Reference: WA/73/17/OUT - Outline Planning application for up to 157 houses on land to the East of Wandleys Lane and West of West Walberton Lane, Walberton by Welbeck Strategic Land.

I write in connection with the above planning application and the recent amendment relating to: - Supplementary plan - Indicative Road Layout and Access plan 38848-5501-004A Rev A. The comments contained in this letter are further to those contained in my letter of objection dated 3rd November. I have examined the plans and my property is adjacent to the subject land, therefore I know the site well. I wish to object strongly to the development of these houses in this location.

Drawing Issue Status					
INDICATIVE - FOR INFORMATION					
LAND EAST OF WANDLEYS LANE A27 / A29 WEST ROUNDABOUT JUNCTION GEOMETRY					
Client					
WELBECK STRATEGIC LAND II LLP					
Date of 1st Issue 29.09.17		Designed JHJ	Drawn MJB		
A3 Scale 1:500		Checked GH	Approved GH

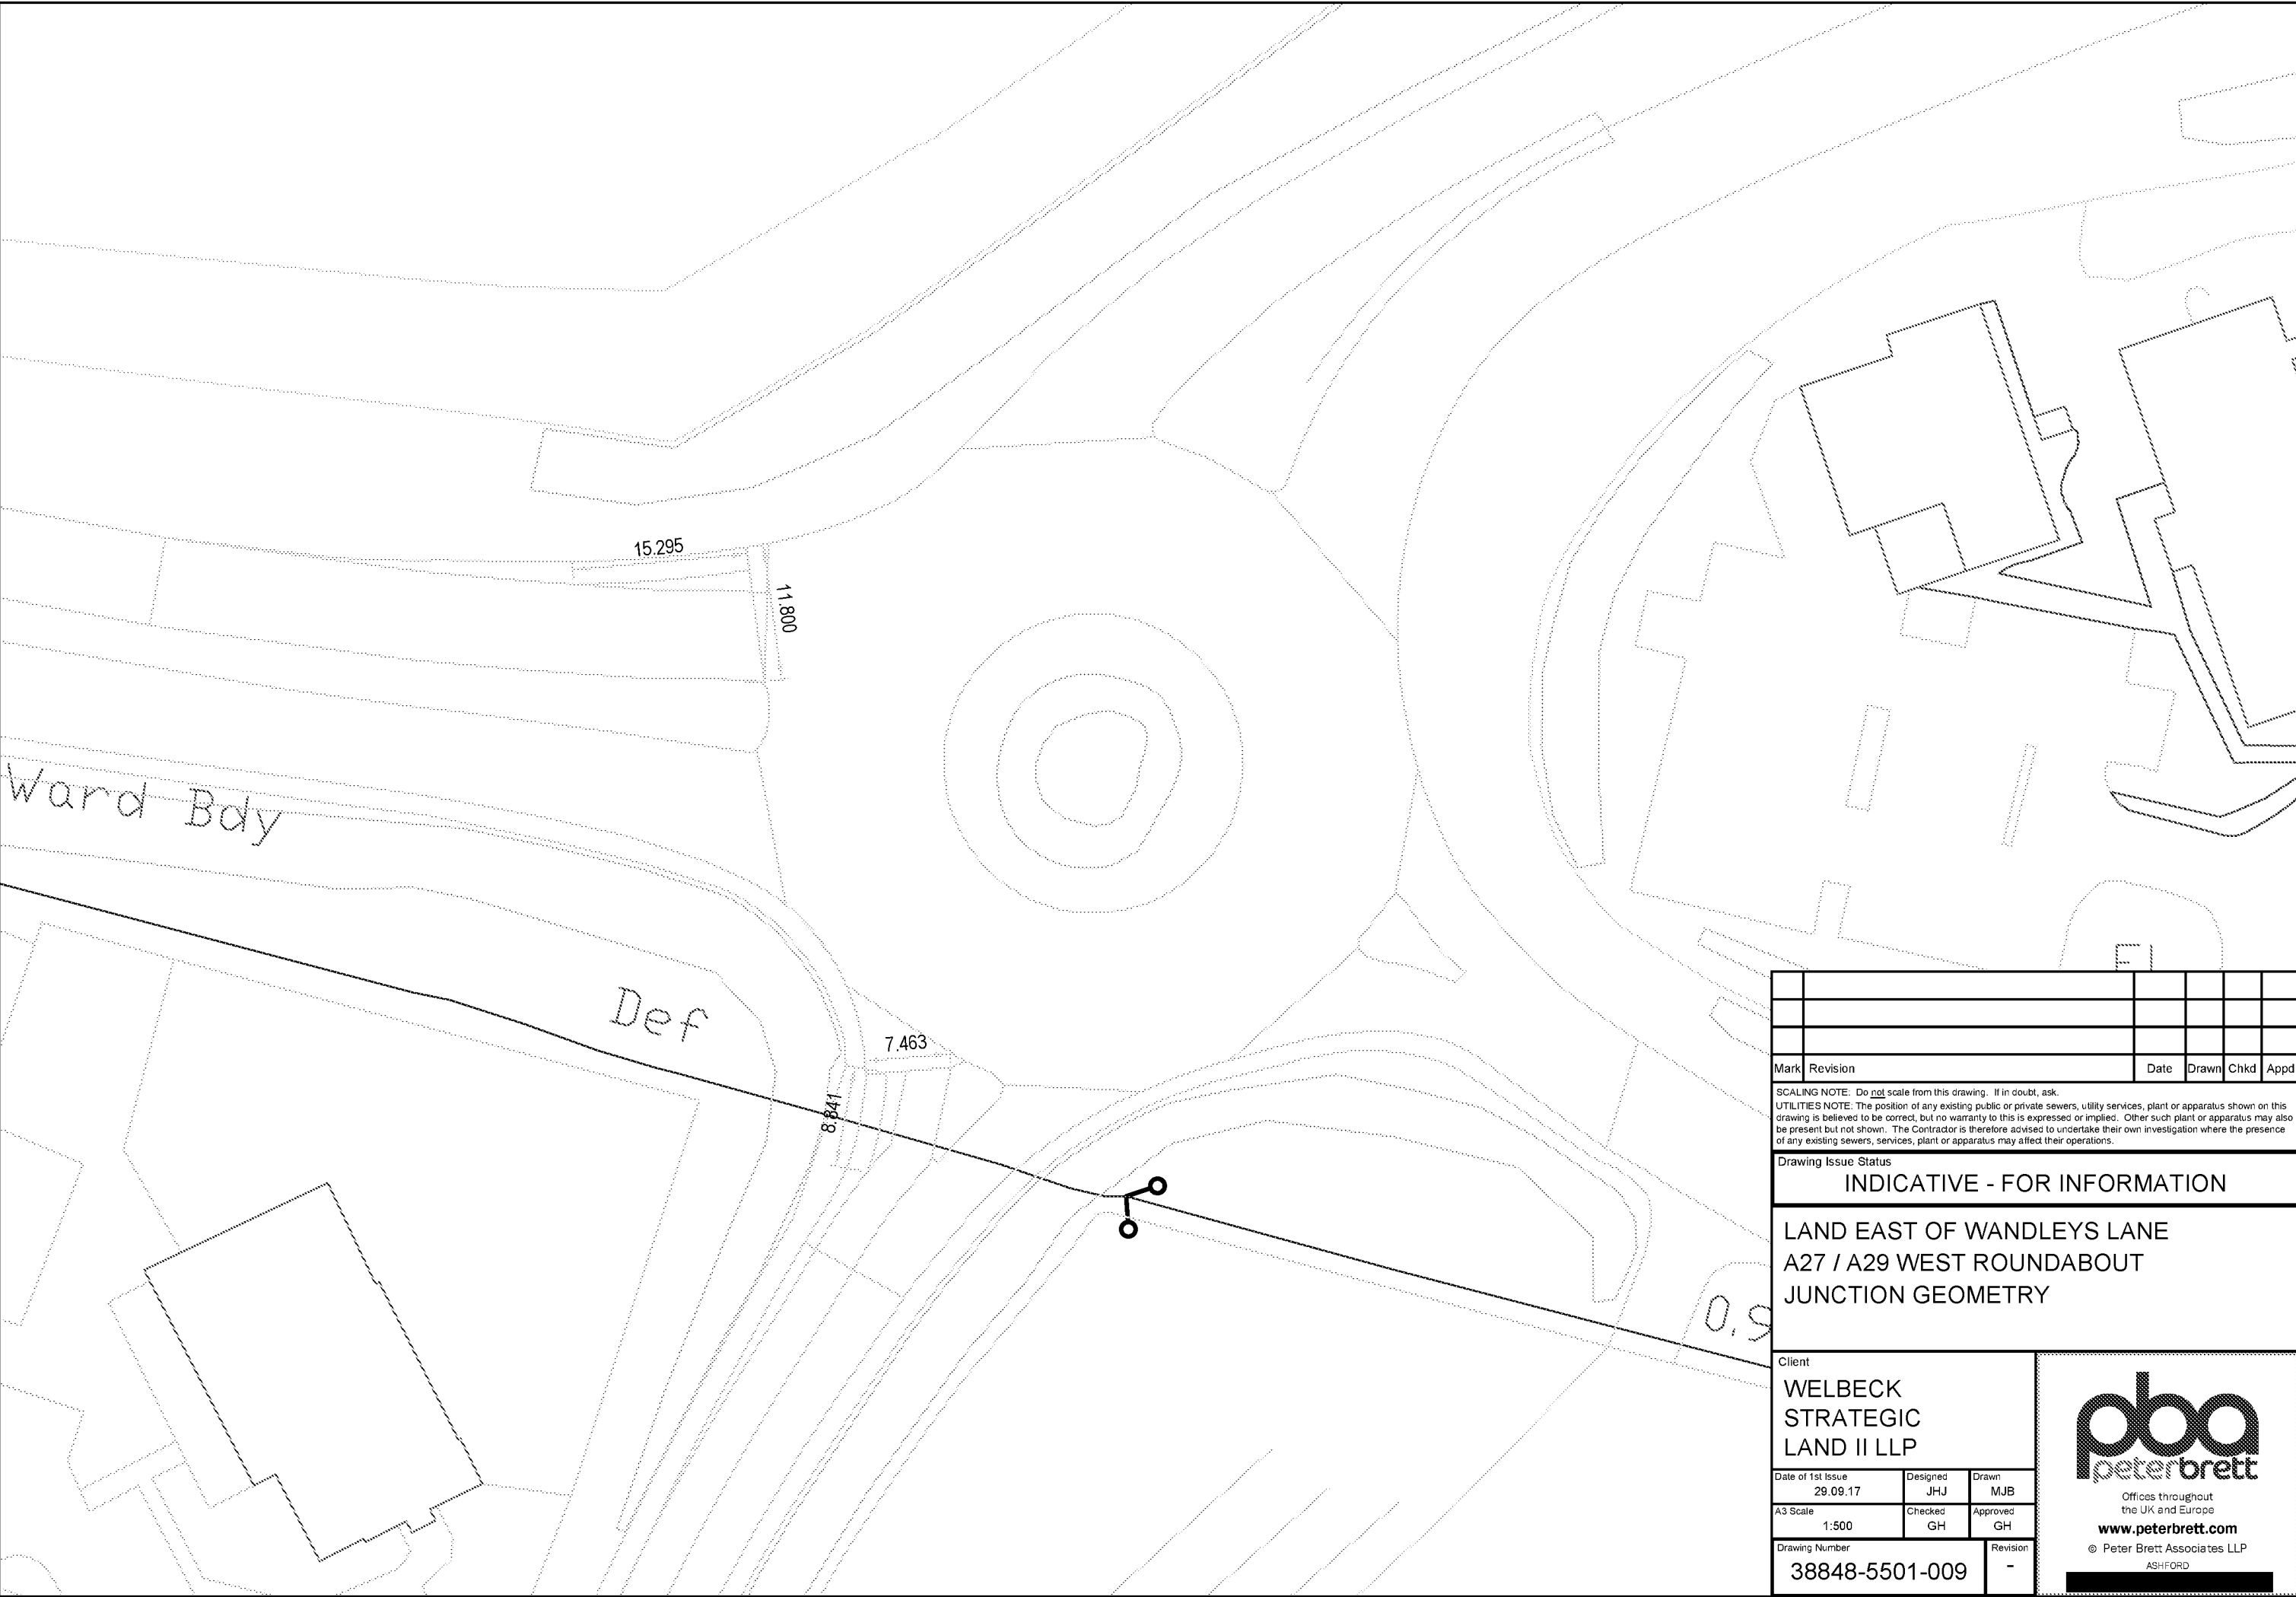
The proposed amendment to the plans is nothing more than a minor cosmetic change to the original application and ceases to address any of the issues raised by the local residents who have objected to this proposed development. The dictionary definition of a lane is; '*a narrow passageway or road especially between fences or hedge. A strip of road for a single line of vehicles*'. The plan to extend the highway to a 6-metre width plus a 1.8-metre-wide footpath could only be achieved in parts of the Lane, with the widespread destruction of established hedgerows and felling of protected trees. The applicant appears to be seeking to transform a lane into a road capable of handling much greater traffic levels; which it will not be able to do.

It is all very well to establish a cycle pedestrian access from the proposed development to the adjacent, as yet unbuilt, Dandara site in order to aid cyclists and pedestrians, however, it does nothing to protect or ensure the safety of any non-development traffic from the potential extra 500 vehicles using Wandleys Lane. Those individuals who already use Wandleys Lane as pedestrians, horse riders or cyclists will be placed at huge risk.

The application seems to be focused on one very incorrect hypothesis; that the majority of the traffic from the site will travel north and so no mitigations are necessary on Wandleys Lane south of the site. This is nothing less than absolute fantasy. Anyone who wishes to go to the nearest railway station, visit the doctor, attend one of the nearby primary or secondary schools, drive to Bognor Regis for shopping or to their place of work will want to head south on the A29. They will therefore not turn right out of the site but left. Who is going to drive three sides of a rectangle if you only need to drive one?
